**From:** Contact Centre (CRM) <contact@ribblevalley.gov.uk>  
**Sent:** 04 February 2025 13:31  
**To:** Planning  
**Subject:** Planning Application Comments - 3/2024/1016 FS-Case-684623990

**Planning Application Reference No.:** 3/2024/1016

**Address of Development:** 1 to 7 The Picture House George Street Whalley BB7 9TH

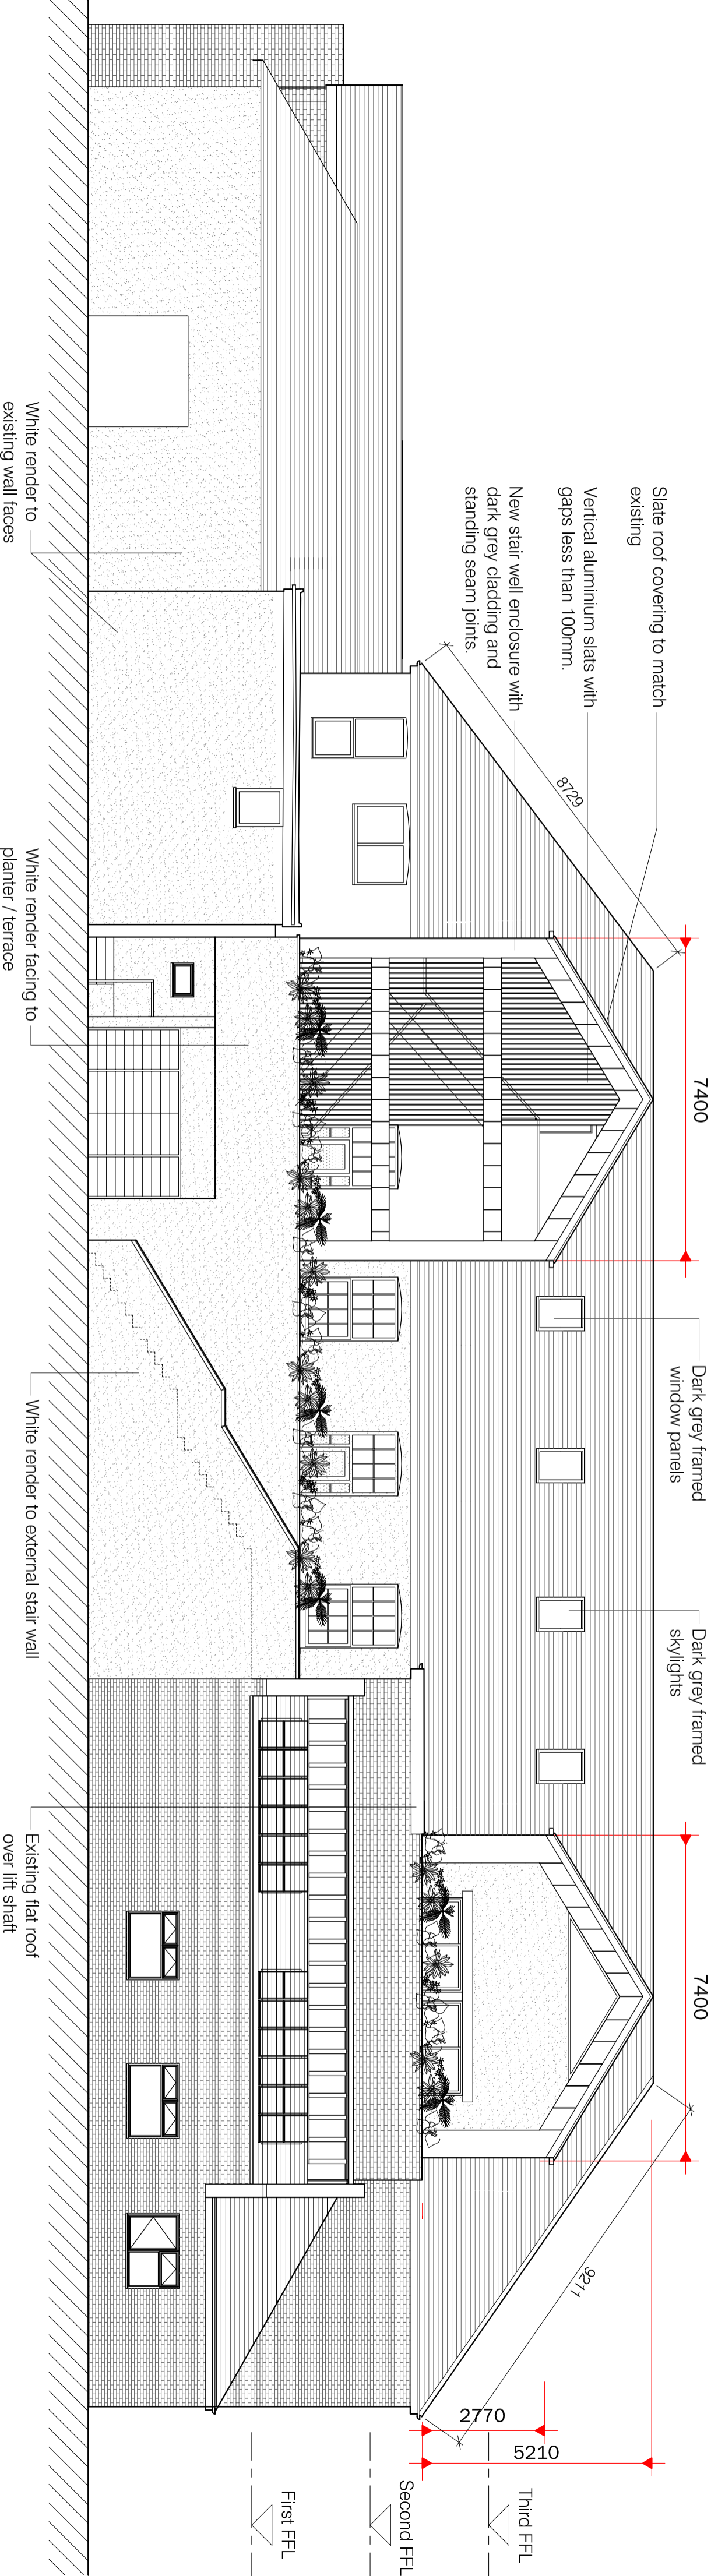
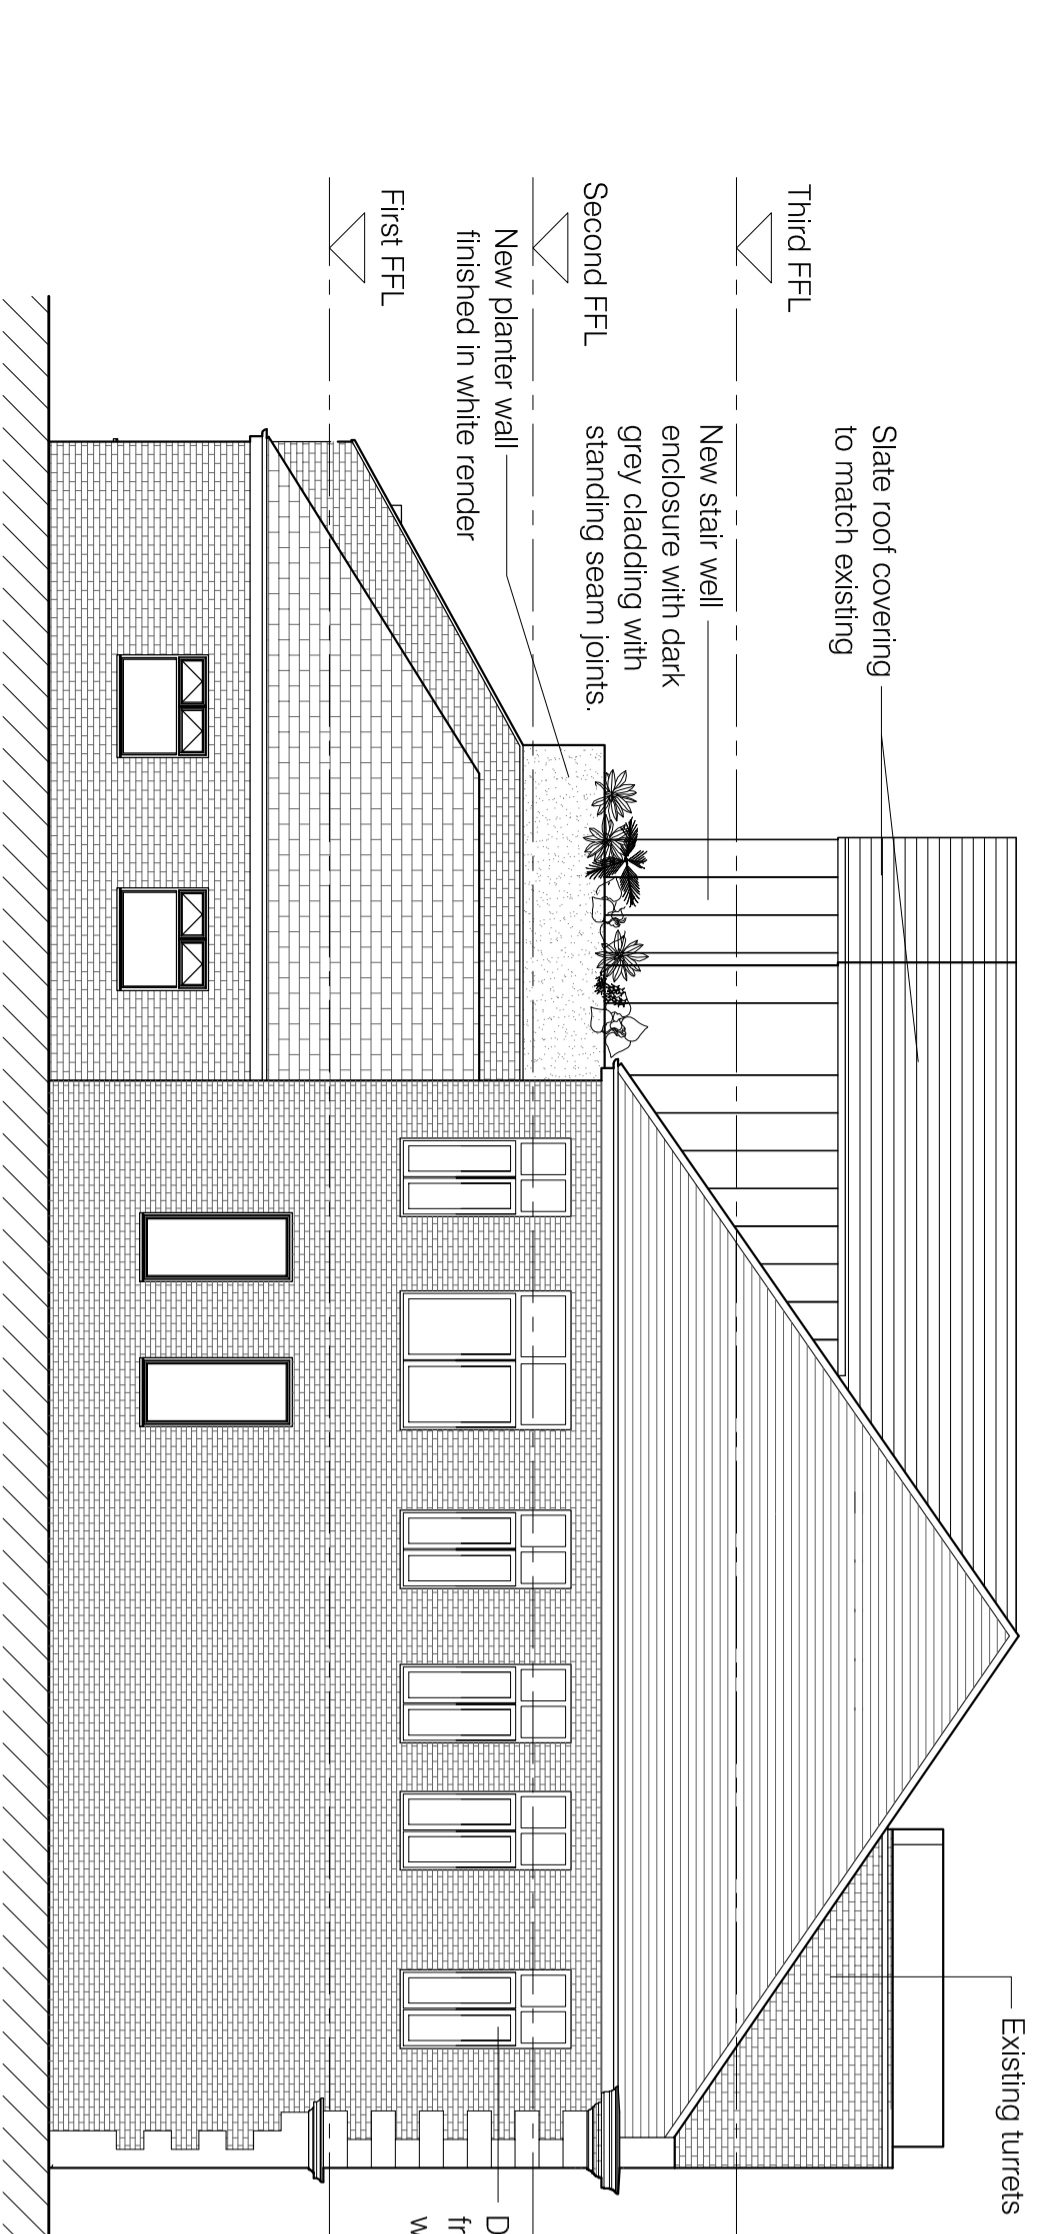
**3. Staircase Alterations and Lack of Glazing**

The alteration to the rear external staircases is particularly problematic. While the applicant states that the glazing has been omitted for cost and programme reasons, it is important to note that this decision effectively undermines the visual quality of the development and alters the approved design. The semi-enclosed stair will also present a safety risk, and this revision could set a worrying precedent for future alterations that could further degrade the integrity of the scheme. The omission of glazing and the resulting appearance of the stairwell are contrary to the original planning approval,

and the applicant should be required to restore the design to the agreed-upon plans.

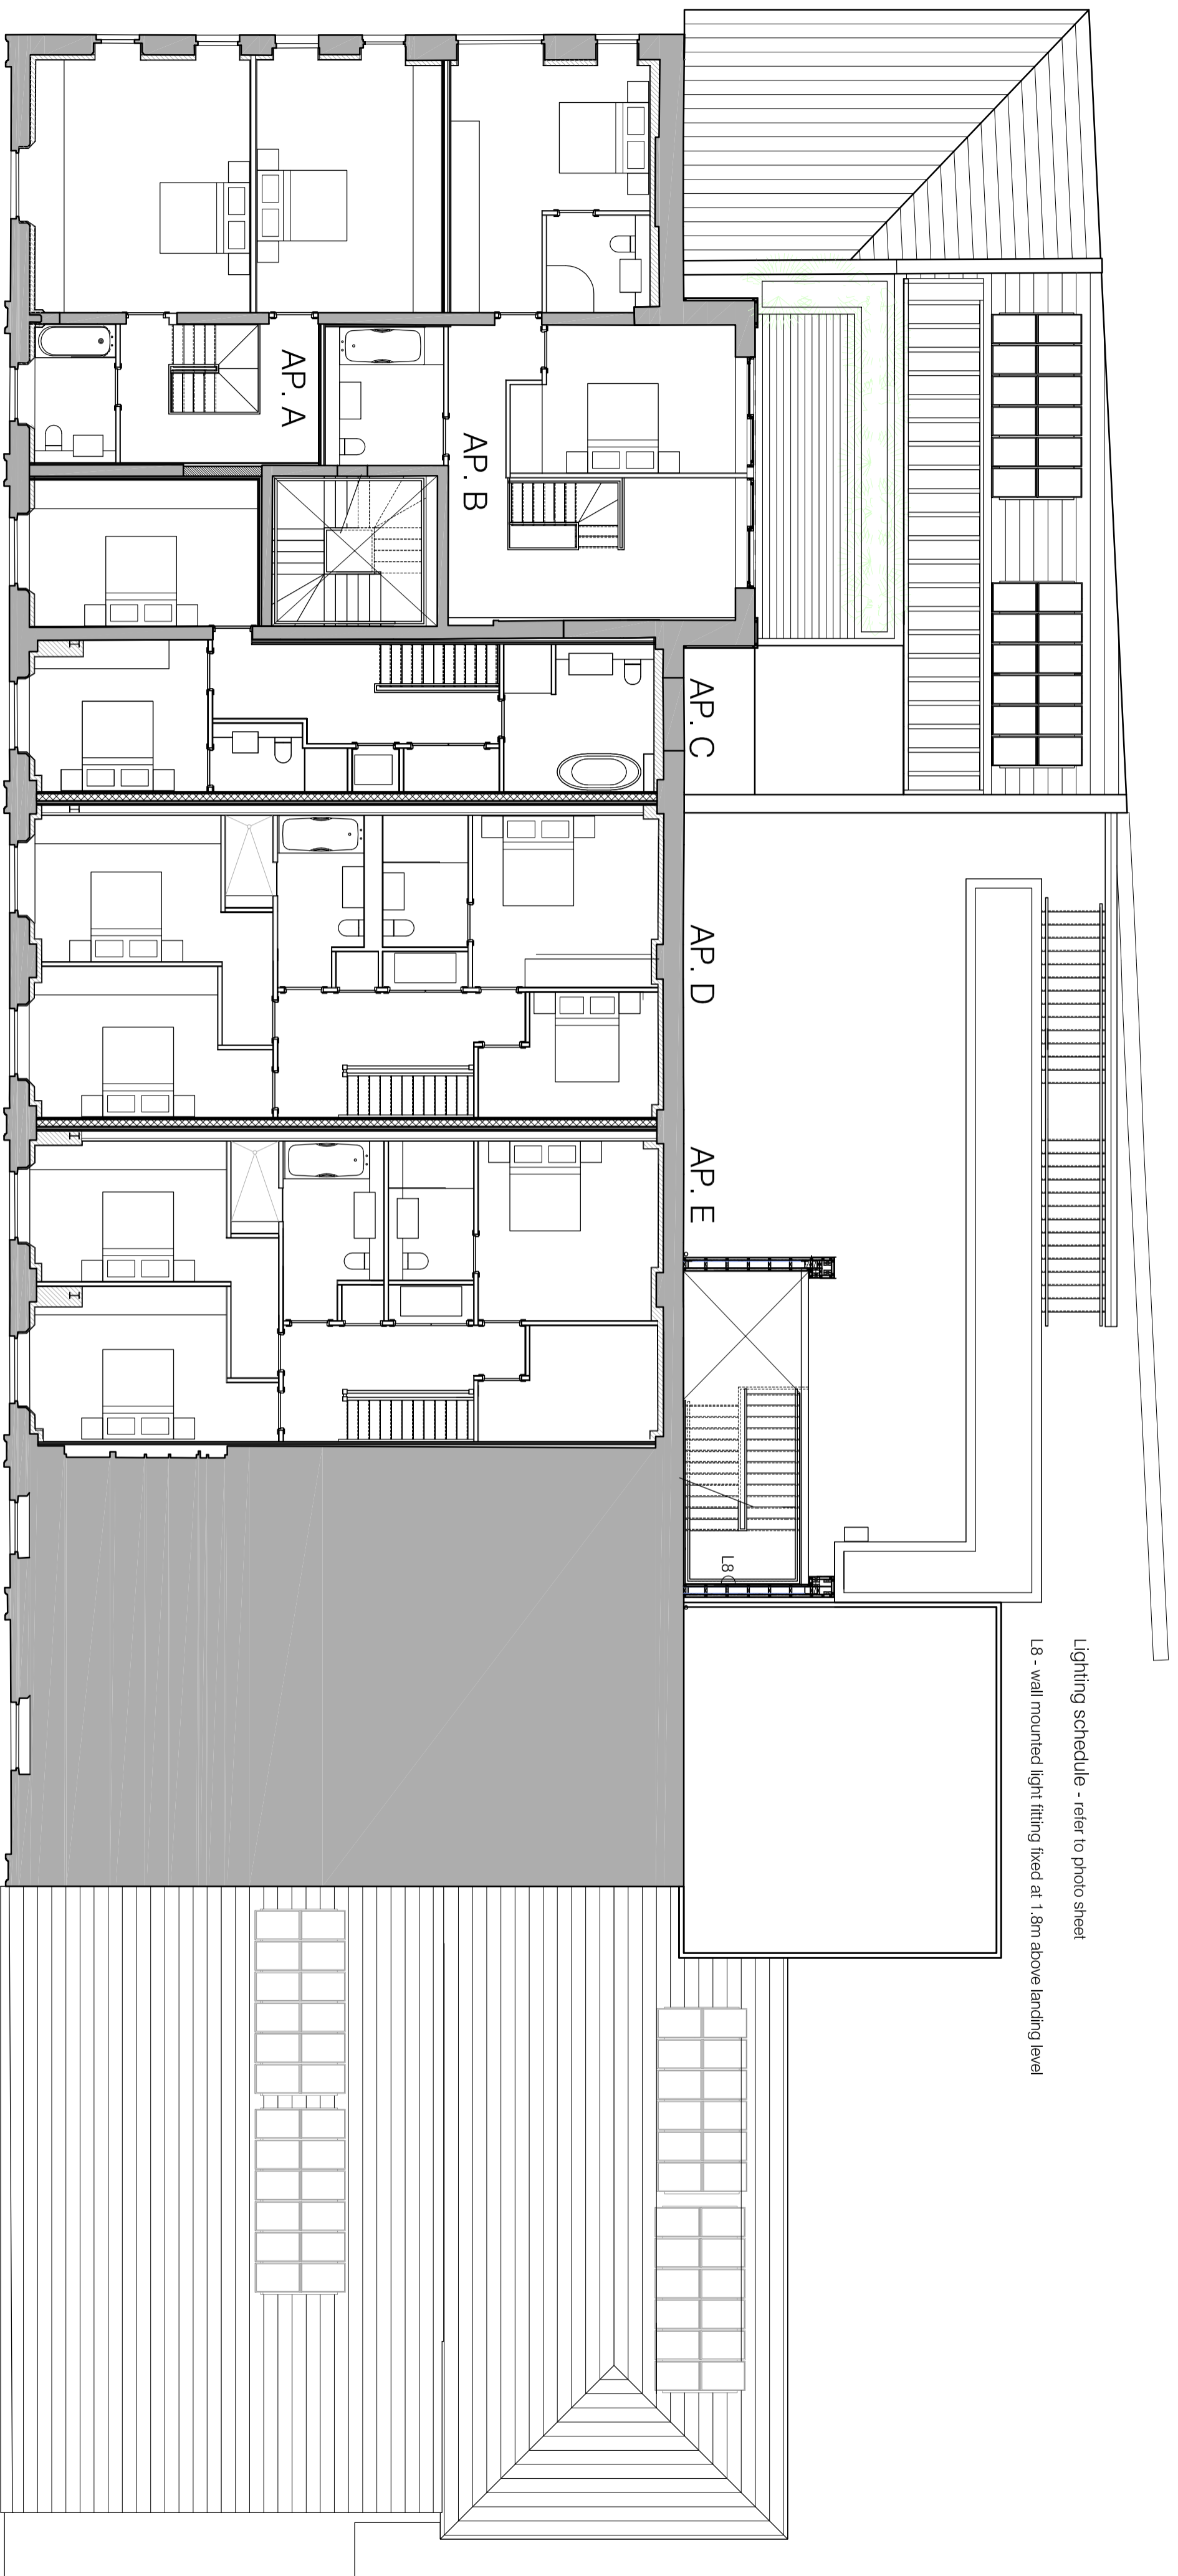
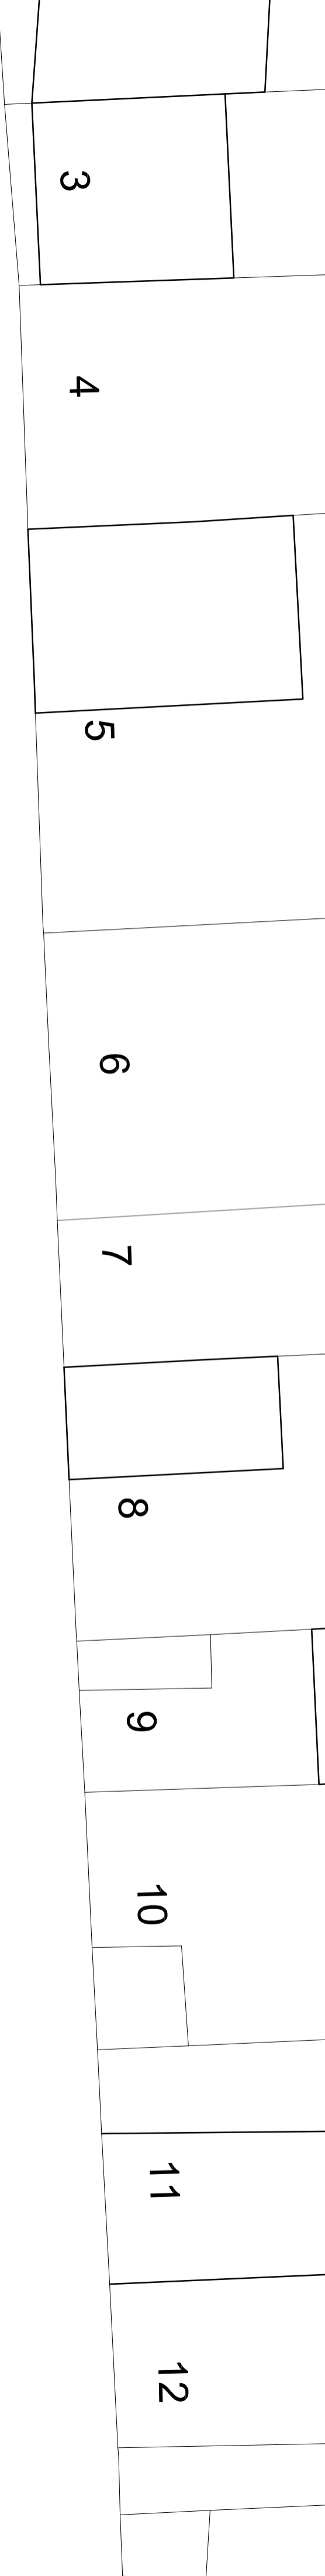
#### 12. External Lighting Scheme

The external lighting scheme, while aimed at enhancing safety and security, must be carefully controlled to avoid light pollution. Excessive or poorly positioned lighting can cause harm to the surrounding environment and detract from the residential amenity of neighbouring properties. A more detailed lighting plan should be submitted to ensure the impact on the area is minimal and that the lighting is in keeping with the character of the location.
